Frazer Park Quarry Resource Recovery Facility

Development Application No SSD 6518

SUBJECT: VOLUME 1 - ENVIRONMENTAL IMPACT STATEMENT - WASTE AND RESOURCE MANAGEMENT FACILITY - SSD 6518 - HODGSON QUARRY PRODUCTS PTY LTD - 800-900 PACIFIC HIGHWAY - FRAZER PARK

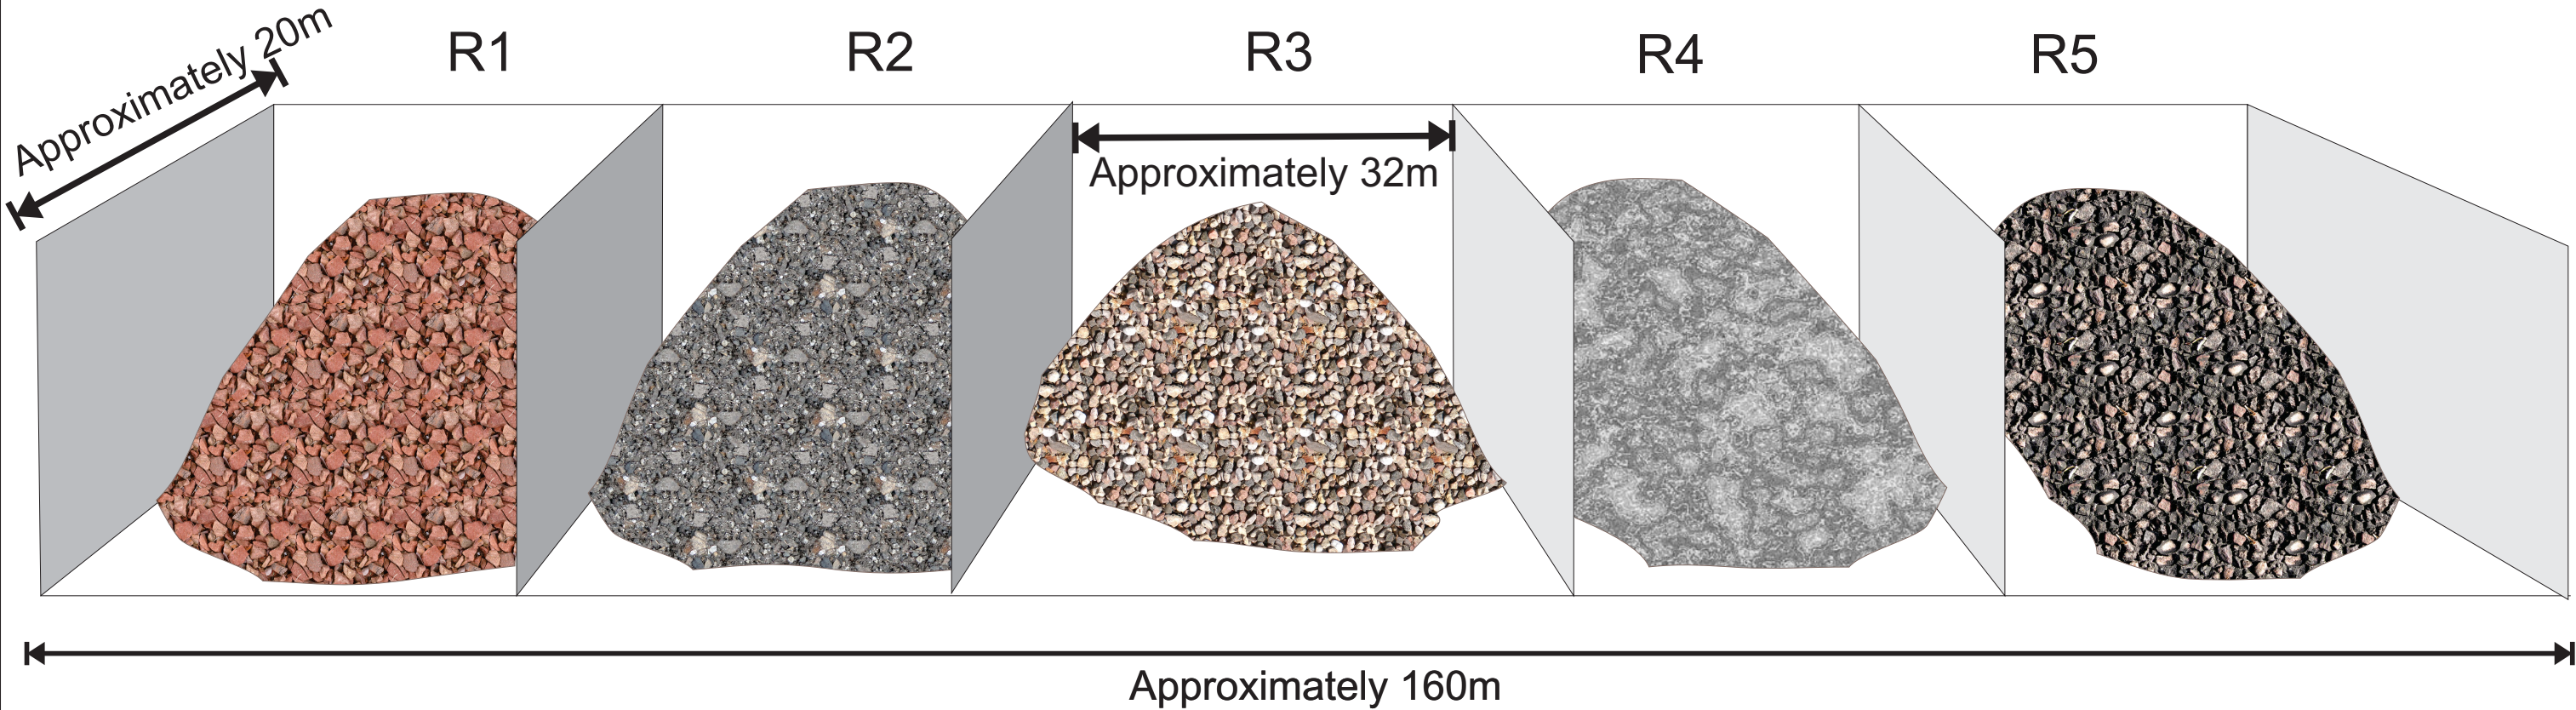
Figure 2.3 – re; general layout of bins in sorting area – design needs to show more detail such as height of these bins plus the type of construction, i.e. concrete walls and concrete graded floor. Also, there is no detail re; water catchment and drainage.

At least design shows the bins have a wall on the southern side to protect against strong prevailing southerly winds. Unfortunately wall height is not mentioned so stockpiles in each bin could be higher than the back walls – therefore, dust pollution could be a major issue if bins are overfilled.

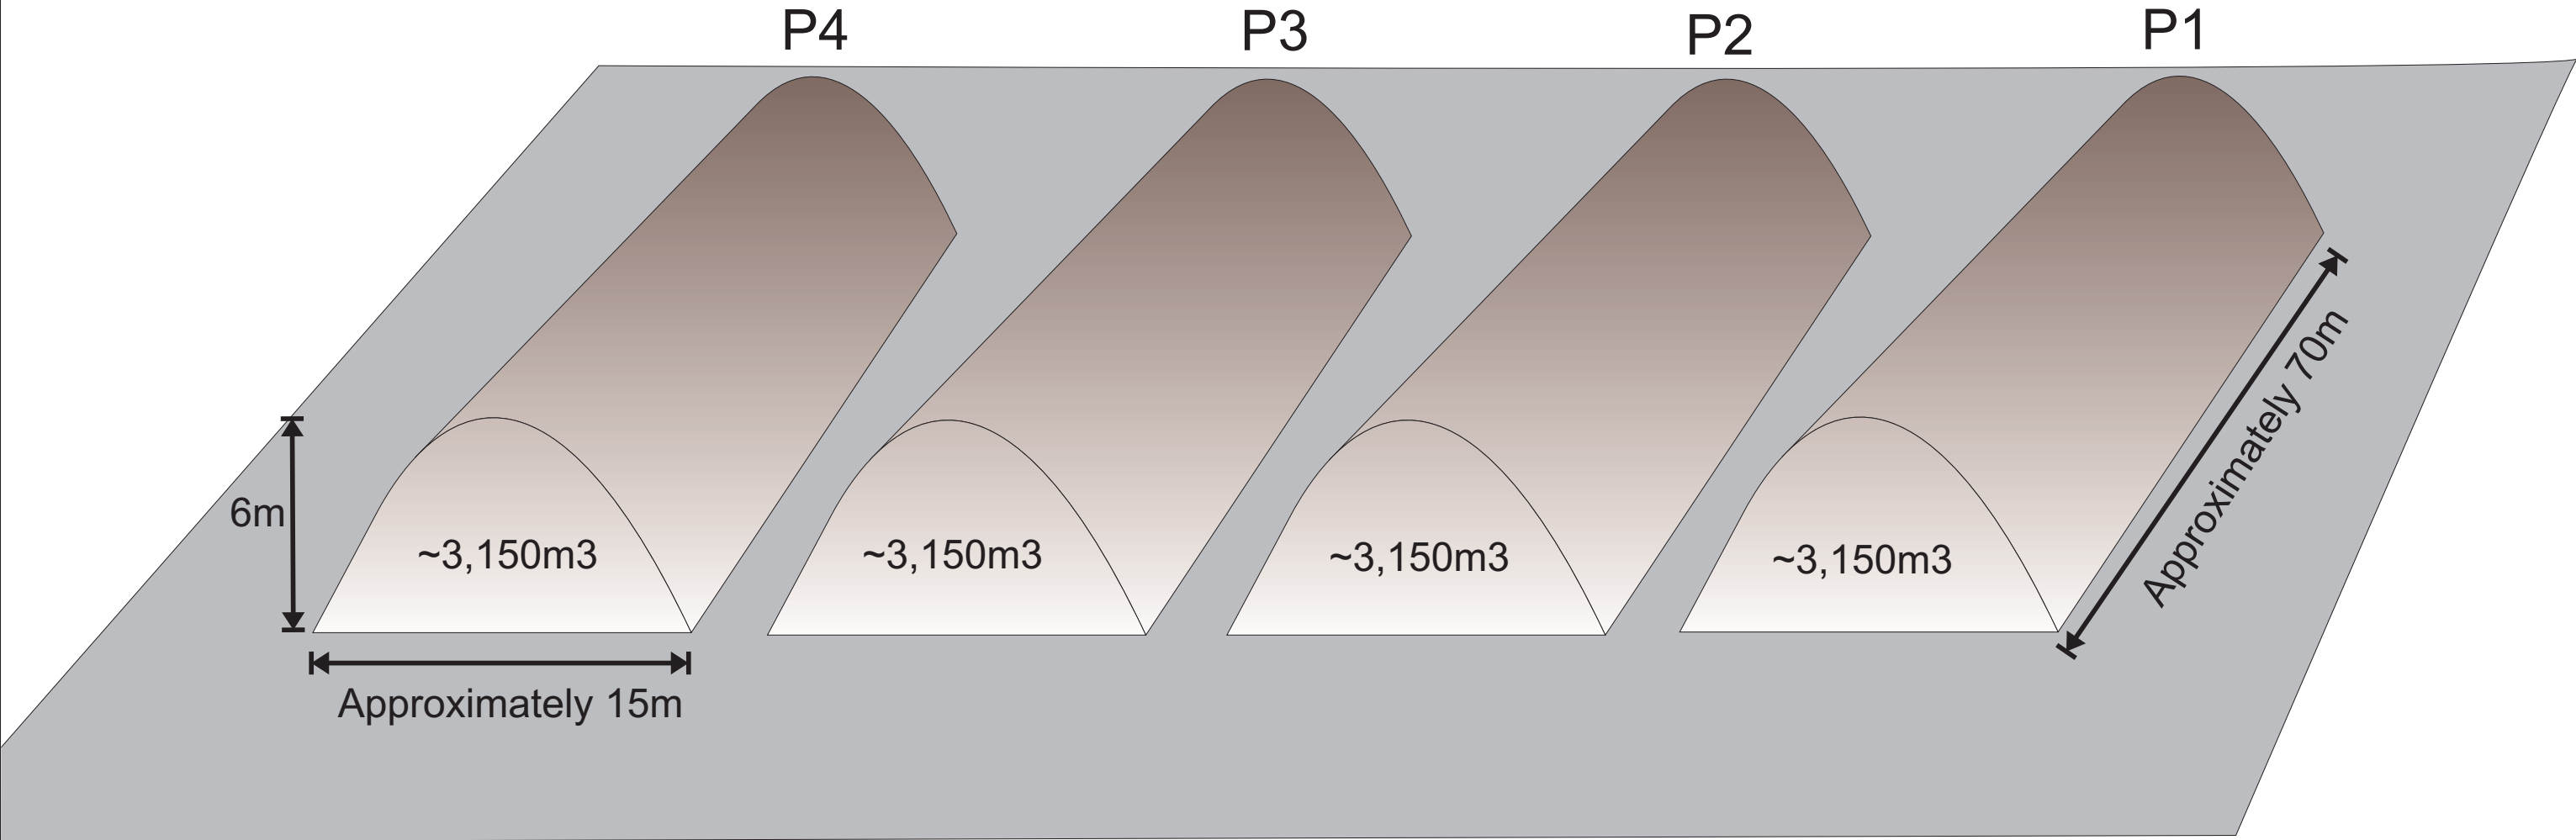
Figure 2.4 – Figure 2.4 Layout of recycled product bins – design needs to show more detail regarding the type of construction, i.e. concrete graded floor and bund walls, as well as water catchment and drainage. This figure title is misleading as this layout shows open stockpiles **NOT** "bins".

These stockpiles cover an approx. area of 100m wide x 70m long and are shown as 6m high. From an environmental perspective these stockpiles, in dry and hot conditions with southerly winds, could result in large amounts of dust being blown onto the Munmorah State Recreational Park as well as Catherine Hill Bay Village and the new 550 house development. These stockpiles are not protected from the strong southerly winds which could spell disaster for the Bay Village and new developments.

Also, there is no mention as to how these large stockpiles (“bins”) are to be managed to minimize the impact of wind and rain.

Objection 30 – Figure 2.4 Layout of recycled product bins – This figure title is misleading as this layout shows stockpiles **NOT** “bins”!

These stockpiles cover a large area of approx. 100m wide x 70m long and are shown as 6m high. As the Erosion Control section restricts stockpiles to 3m, why are the stockpiles in Figure 2.4 shown as 6m high?
